Re: Review letter for The Bluffs at Whiskey Ridge (PA22-019)

**Re: Bluffs at Whiskey Ridge (FKA Groundhog PRD) – PA22-019 - Final Review 1**

P.O. BOX 289, WOODINVILLE, WA 98072 425.486.1252 WWW.ATWELL-GROUP.COM	
PROJ. NO. 23026/23005457	SHEET 2 OF 4

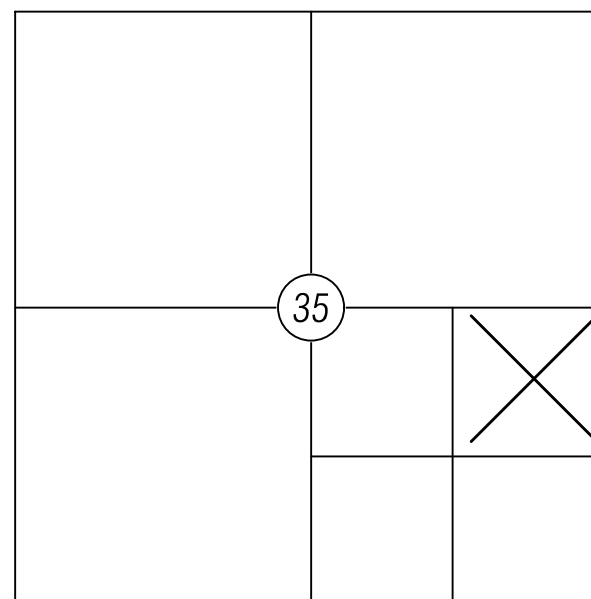
Dedication of Tract 996 for access and maintenance of a city-owned sewer main will be required.

**An easement has been added (Easement provisions No. 7 on sheet 2) for the sewer main across the tract.**
